Recommendation Report for Planning Permission for Works or Extension to a Dwelling

REF NO: FP/24/19/HH

LOCATION: 7 Ivanhoe Place
Felpham
PO22 7QN

PROPOSAL: Single storey side extension including demolition of existing conservatory

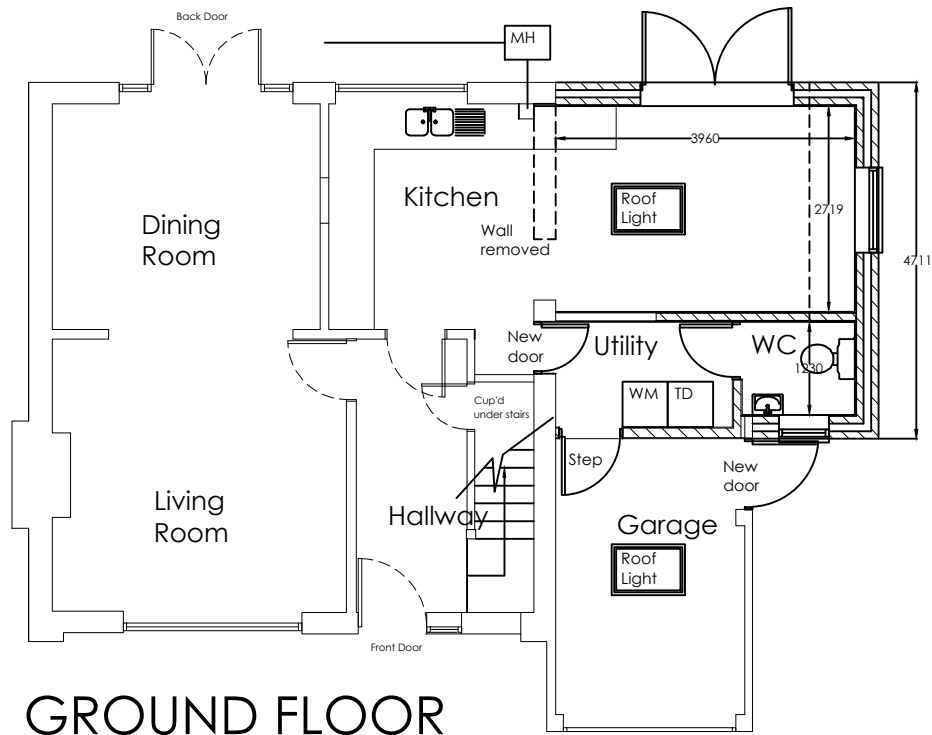
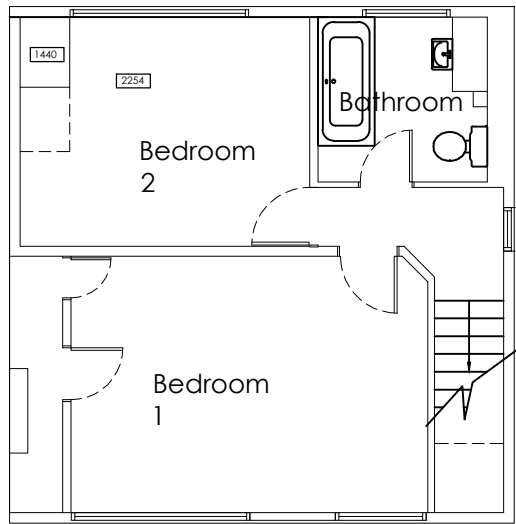
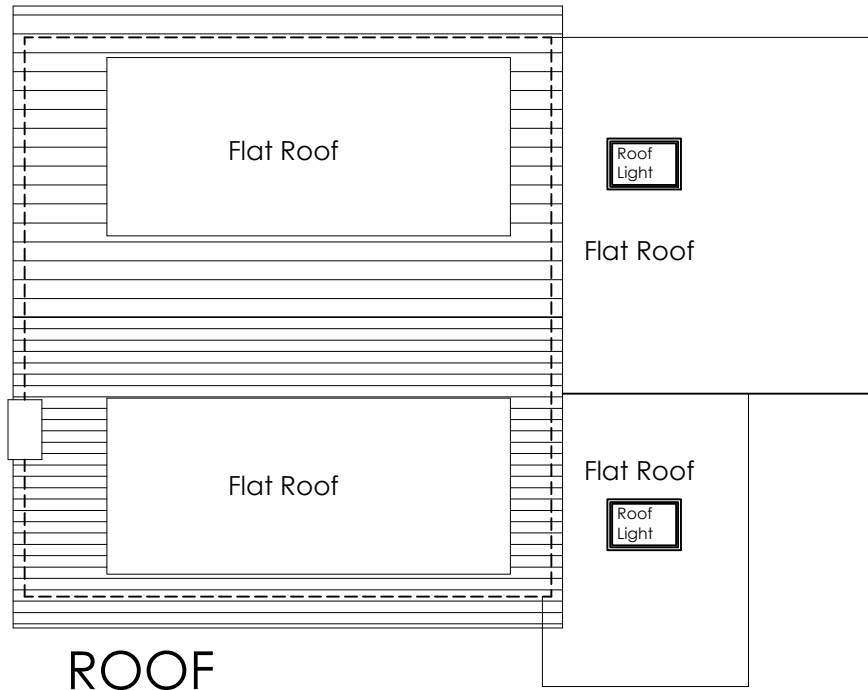
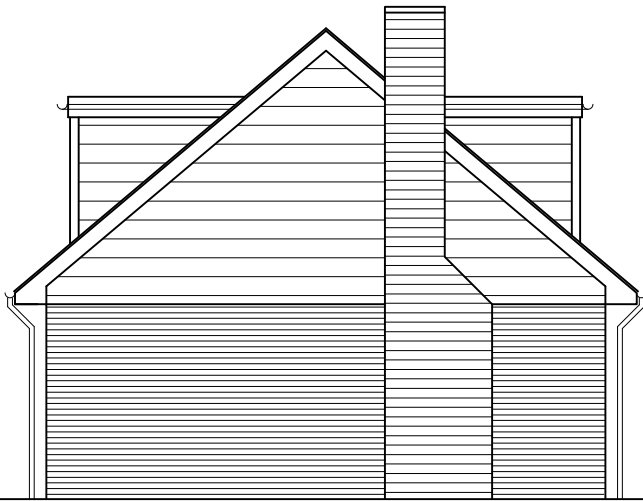
The application seeks planning permission for the construction of a single storey extension including the demolition of an existing conservatory. The proposed extension given its location will be somewhat visible within the street scene, however it will appear as well integrated with the host dwelling. Part of the existing attached garage will be incorporated into the side extension to form a small utility room.

The proposed side extension will measure approximately 4.7m in length, 4.4m in width and be built to a proposed height of 3.1m including the roof light. Given the proposed extension is replacing an existing conservatory that will be demolished and is partly shielded by an existing attached garage, it is not considered to have a detrimental impact on the character of the host dwelling or the street scene.

approximately 4.5m from the Eastern boundary, 1m (at its closest point) to the Southern boundary and approximately 8m from the primary Western elevation. The proposed extension will feature 1No. window on the Southern elevation, 1No. window on the Western (primary) elevation and double doors on the Eastern elevation. The window on the Southern elevation is not considered to give rise to any additional overlooking given its on the ground floor and overlooking the side of the properties garden. The window on the primary elevation (Western) is again at ground level and given the window will be obscured and overlooking the road is not considered to give rise to any additional overlooking on the neighbouring properties.

Given the distance from the double doors and the Eastern boundary of the site is approximately 7.5m and will overlook the rear garden at ground floor level, they will not give rise to any additional overlooking or loss of privacy to the neighbouring properties. The extension will also include 2No. roof lights, however by virtue of the design of the proposed extension and the location of these windows, they will not result in any unacceptably adverse overlooking of neighbouring properties.
